Historic England

WRITTEN REPRESENTATIONS

Dogger Bank South Offshore Wind Farm Projects (Reference No.

Application by

Visualisation showing Proposed Onshore Converter Stations

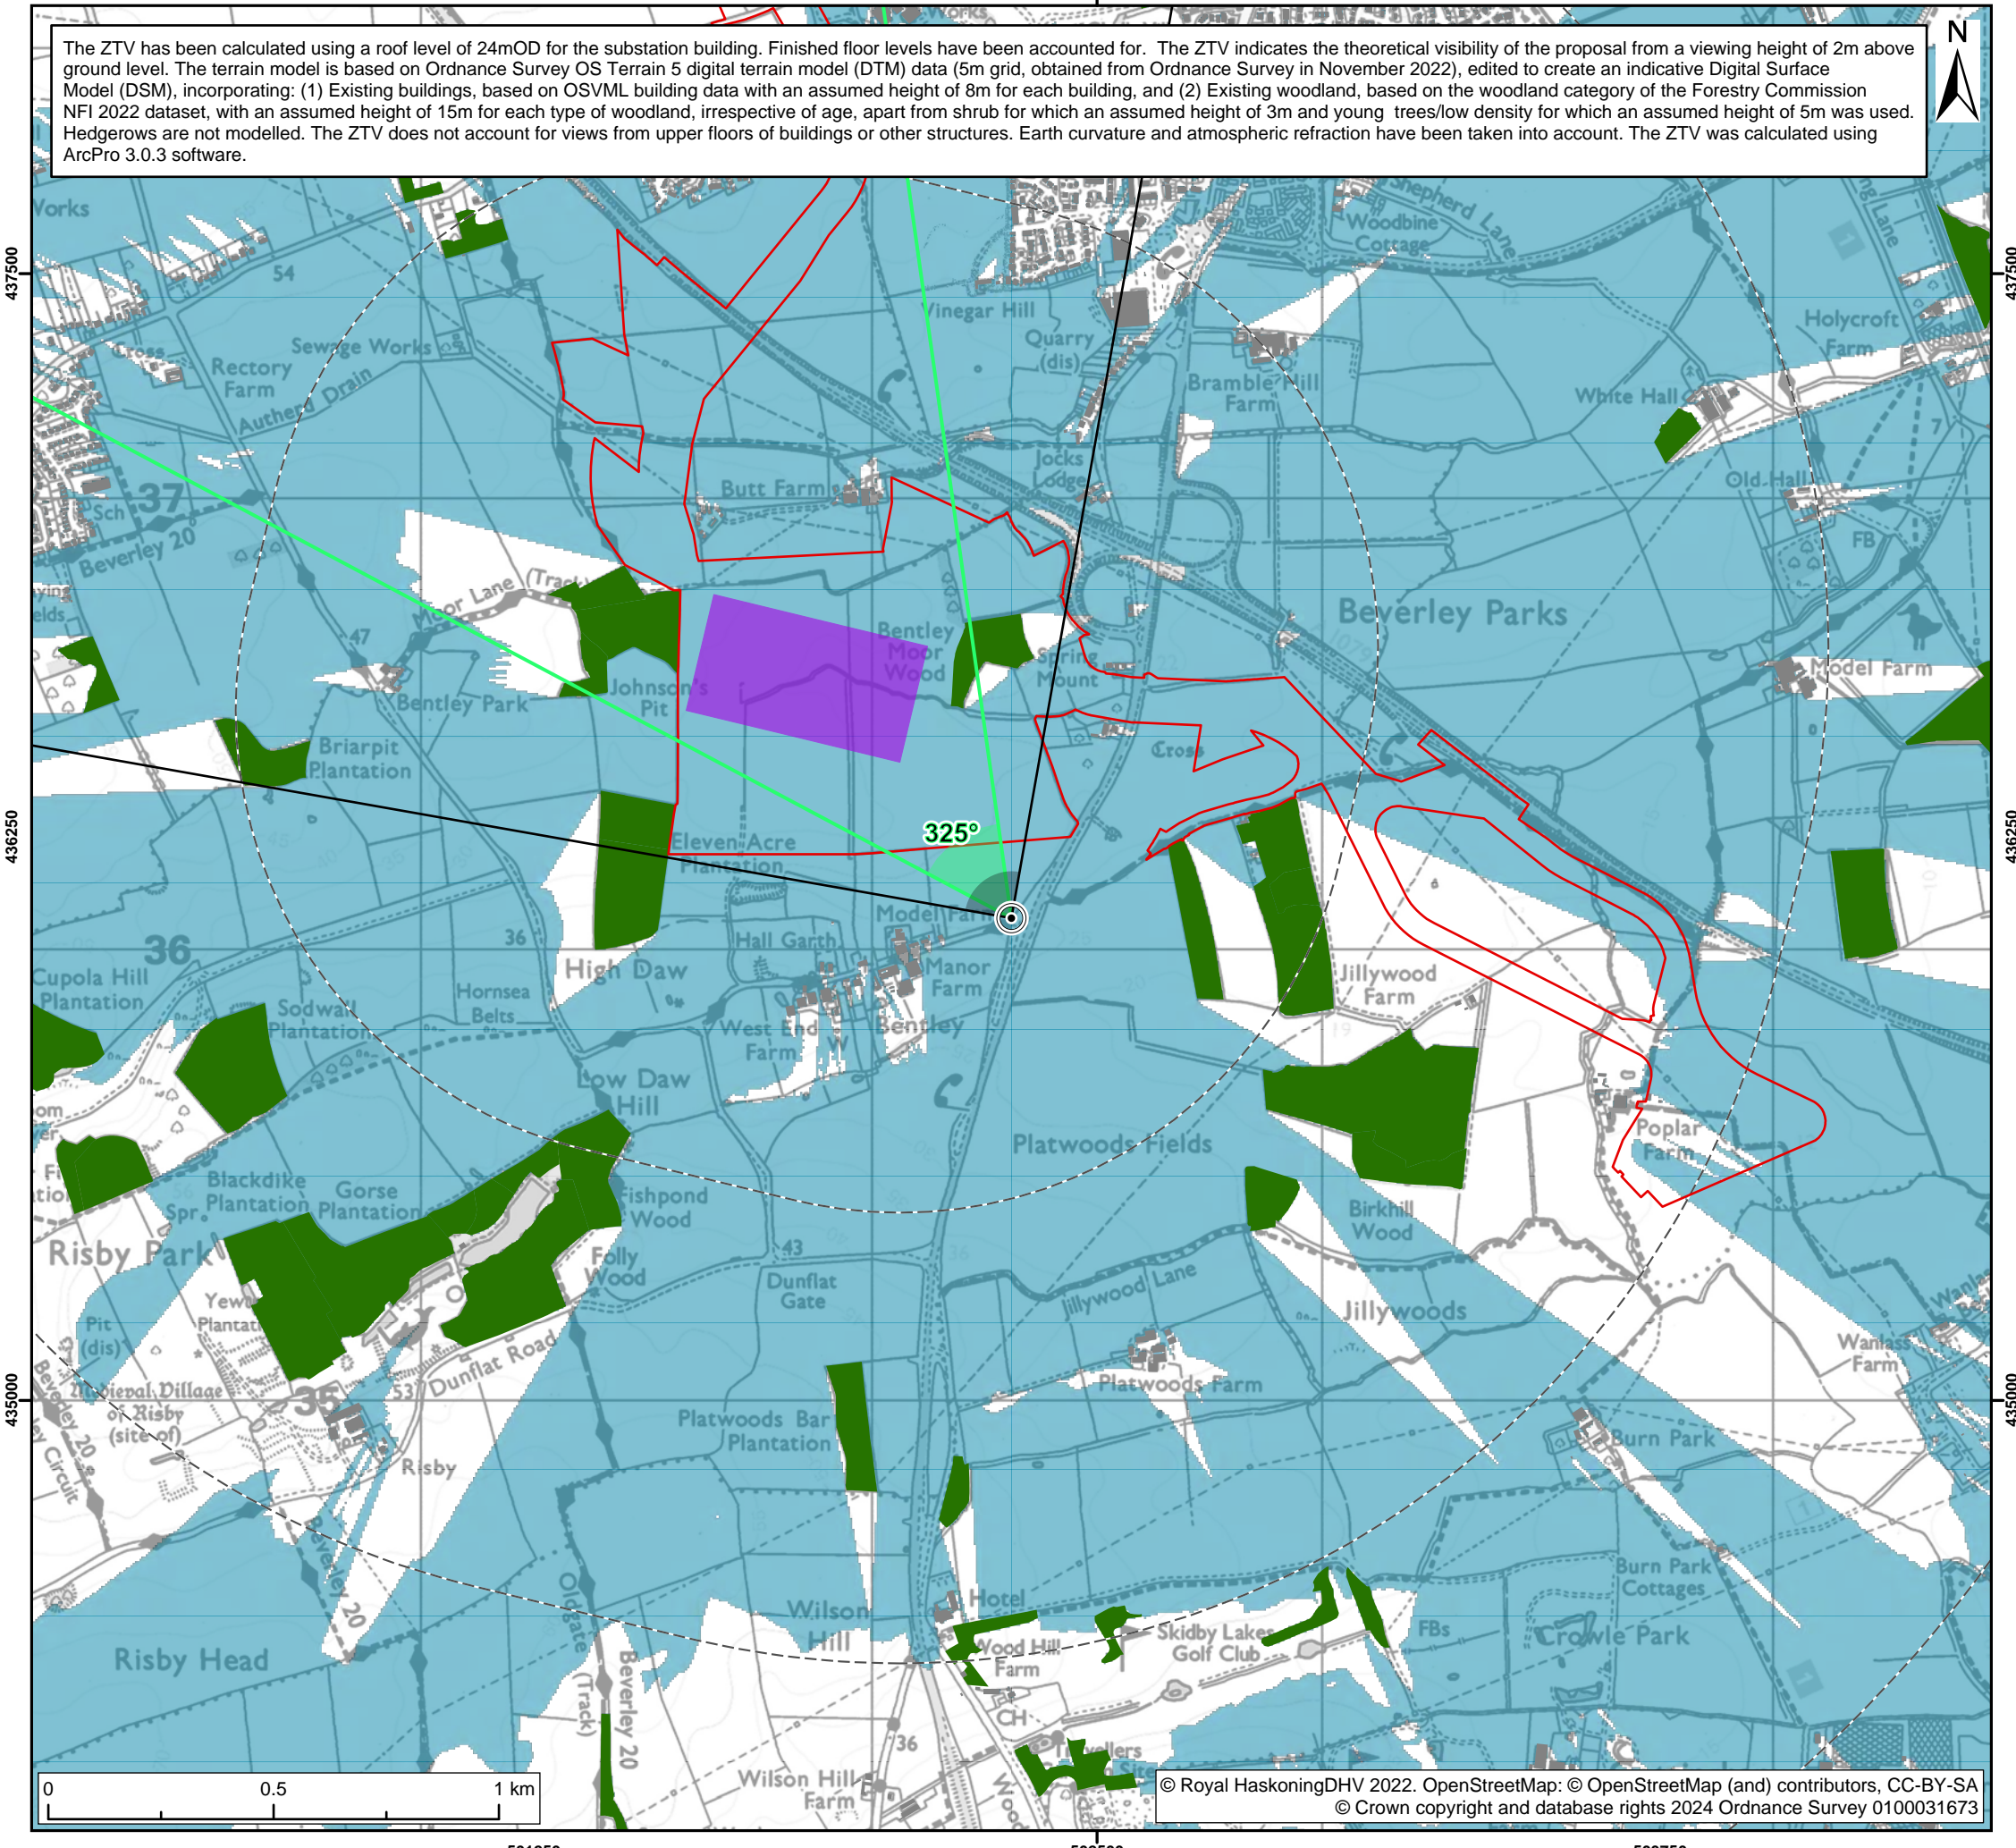
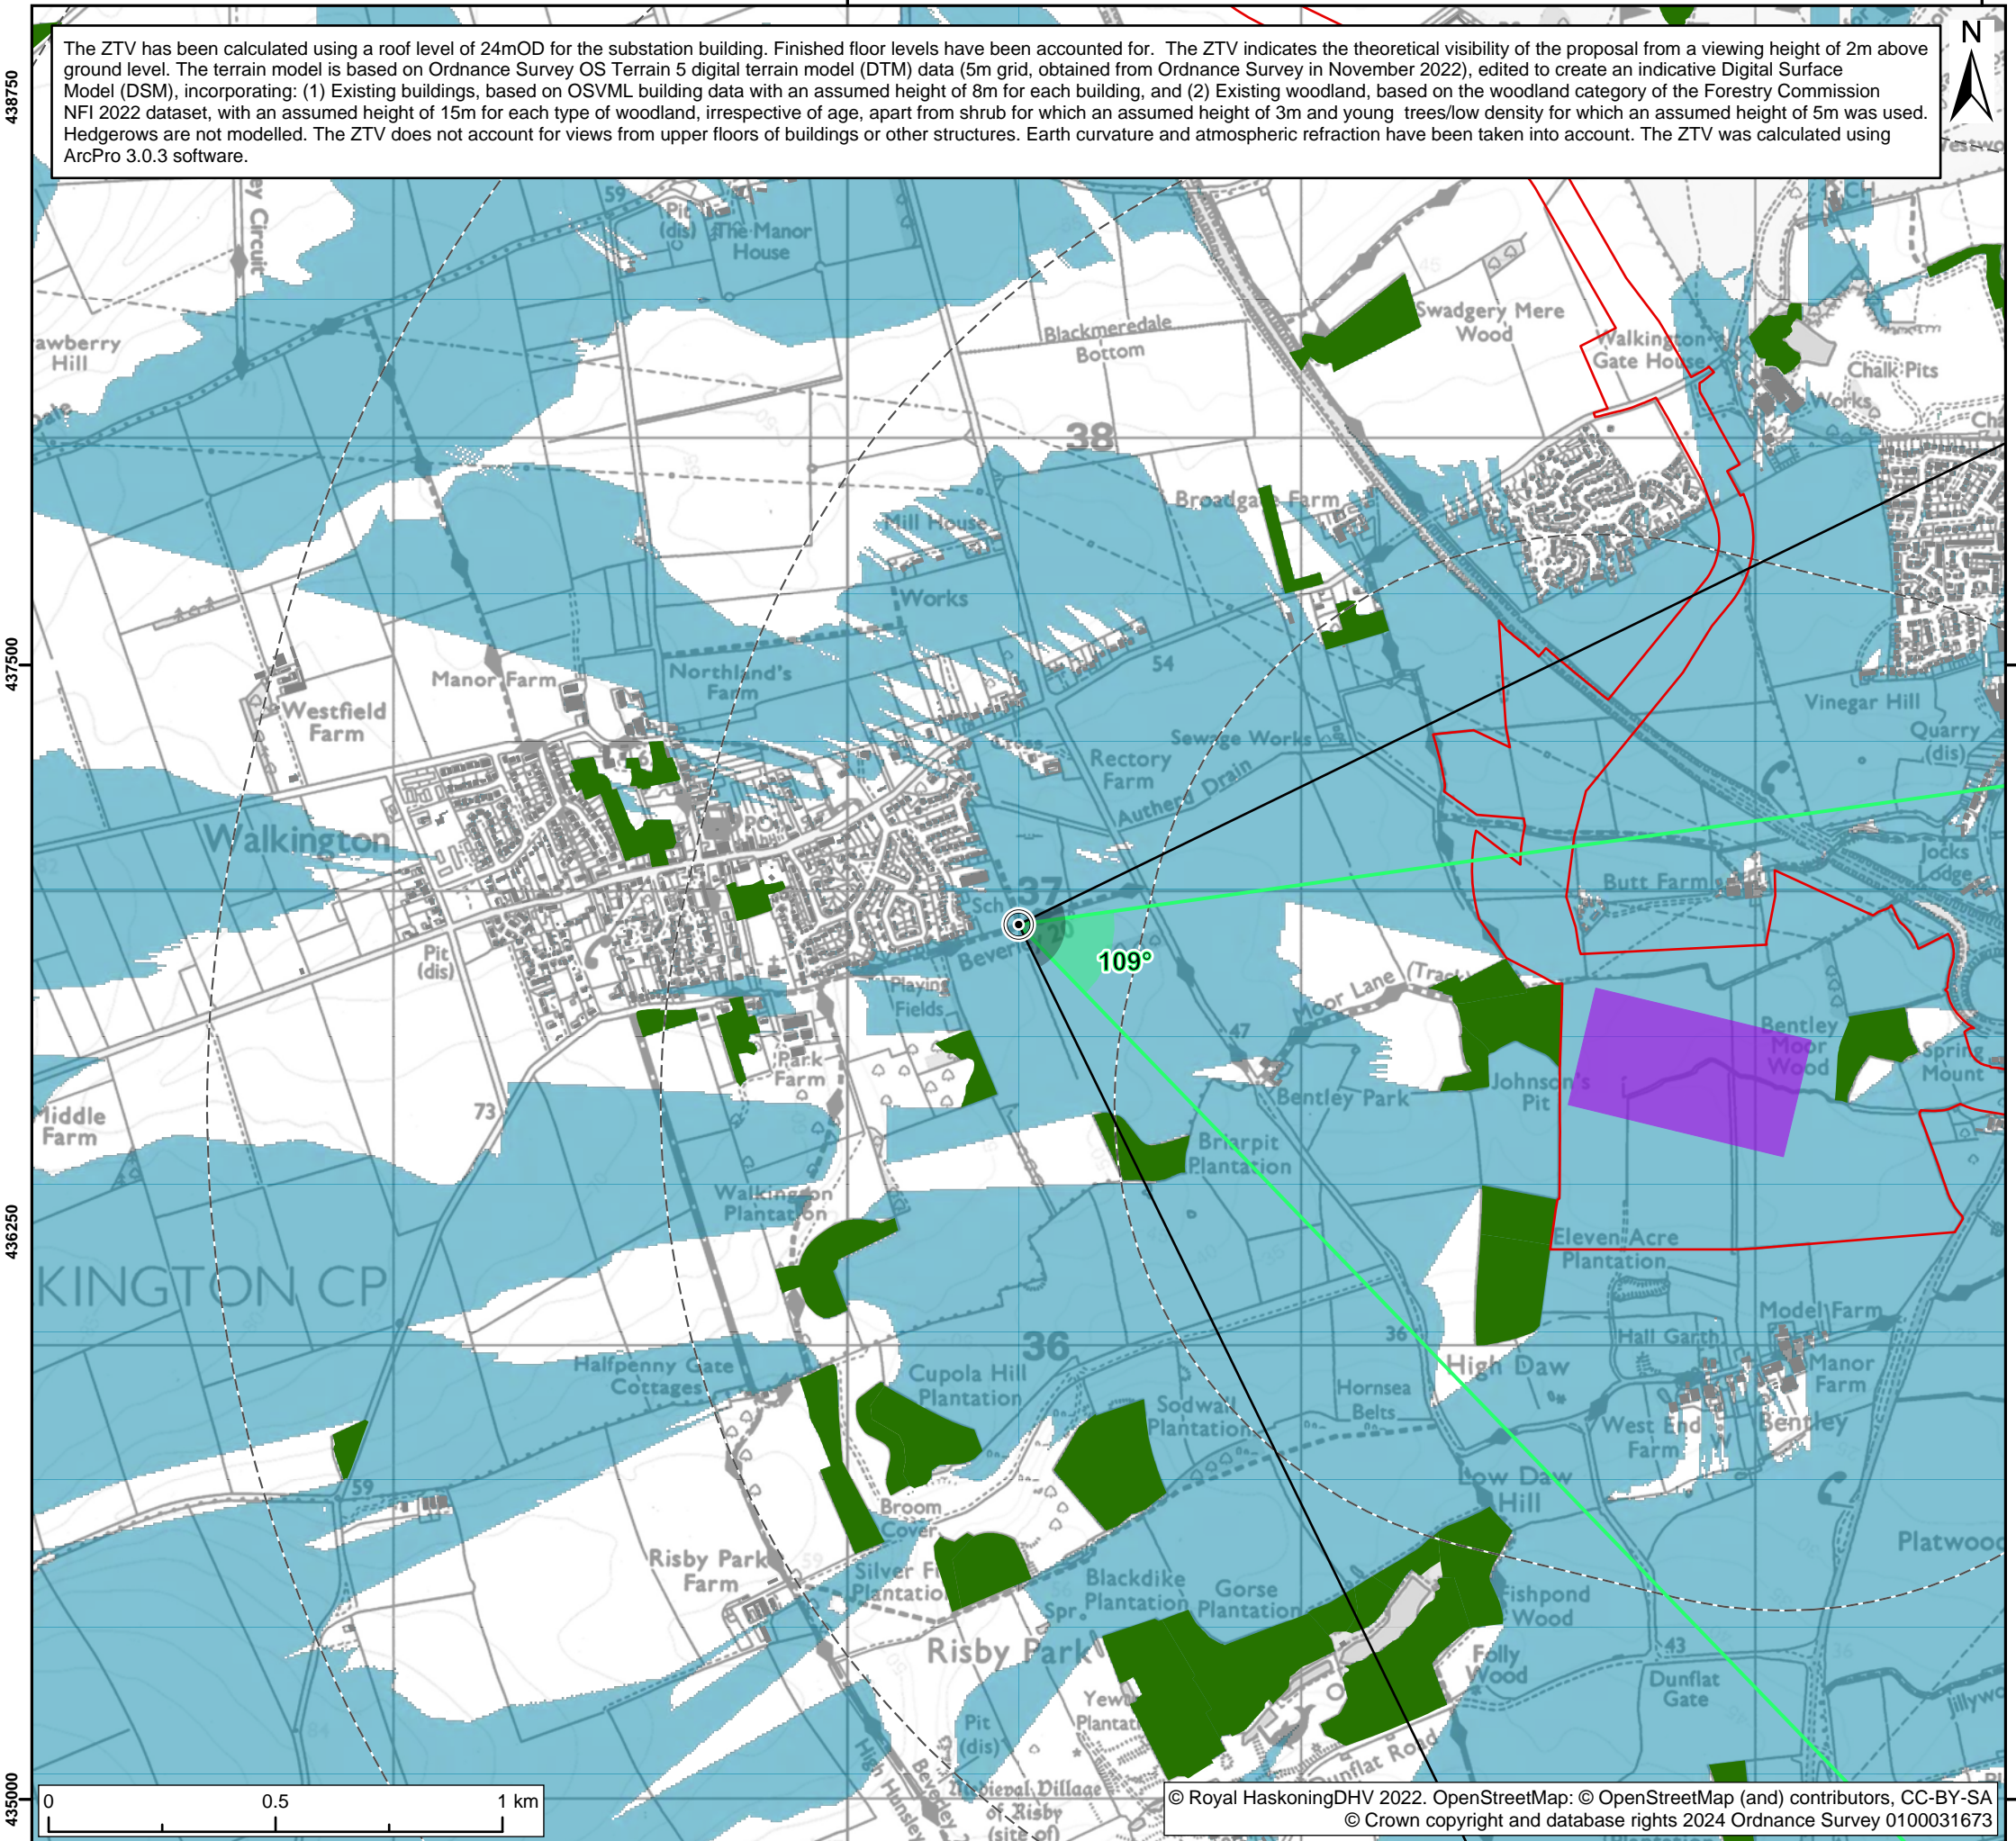
- 4.5 The Project Change Request proposes the reduction in size of the footprint of the proposed OCS, previously depicted as a visualisation ([APP-192] for Landscape and Visual text, para 23.6.2.3.1 onwards, and [APP-193] Fig 23-15a2; [APP-193] Fig 23-15a3). These visualisations presented a 'worst case scenario' (two Onshore Converter Stations within the Converter Station Area) and indicated the scale and massing of one possible product of the scheme, as seen from the nationally important Scheduled Monument of 'Heavy Anti-aircraft Gunsite, 350m west of Butt Farm', NHLE 1019186 (the "Butt Farm Gunsite").

- 4.7 The extent, massing, scale of the proposed OCS structure and its proximity to the Scheduled Monument represented a considerable concern for Historic England. We considered that the proposed Converter Station(s) represented 'less than substantial harm' to the significance of the site, but at the high end of this scale, owing to the manner in which the experience of being on the scheduled site would be diminished by the over-bearing presence and scale of the Converter Station(s). The proposed Converter Station(s) would significantly reduce the open quality of the landscape setting of the scheduled monument, and hinder understanding of its wartime use.

- 4.8 Following the change request, it is now proposed that the footprint of the OCS is to be reduced in scale. We note and welcome the reduction in the size of the footprint and agree that the proposed reduction in scale of the OCS will lead to a reduced potential for effects on buried archaeology and a reduced visual impact when seen from the Butt Farm Gunsite. However, we consider that the harm to the significance of the designated site will remain at 'major adverse', and not 'minor adverse' as suggested by the Applicants. This high degree of 'harm' needs to be addressed. This can be achieved by reducing the impact of the building, or finding ways to mitigate the harm it would cause. We do not consider that screening through planting is an effective or lasting mitigation measure in this instance and have referred to this in our response to the ExA's questions of 10th January 2025 (Question ISH 2.10.12).

- 4.9 It is clear from the supporting text in the Environmental Statement ([APP-192], para 91, page 69) and the Project Change Request that the design component of the OCS is a work in progress. The Project Change proposals have not been confirmed, whilst [APP-192], para 93, page 69 states that the Environmental

Statement visualisation does ‘not show details of finishes or colours...’. The Applicants have yet to provide a visualisation of the Converter Station at night showing the impact of any service or security lighting.

- 4.10 Therefore, it is not yet possible to understand the full impact of the built element of the scheme on the setting and significance of the scheduled Butt Farm Gunsite. To address this aspect of the proposed development the maximum height, footprint, landscaping scheme and precise location of the Converter Station is to be fixed at DCO stage. If DCO is granted the final details will need to be carefully assessed as part of any post-consent determination.
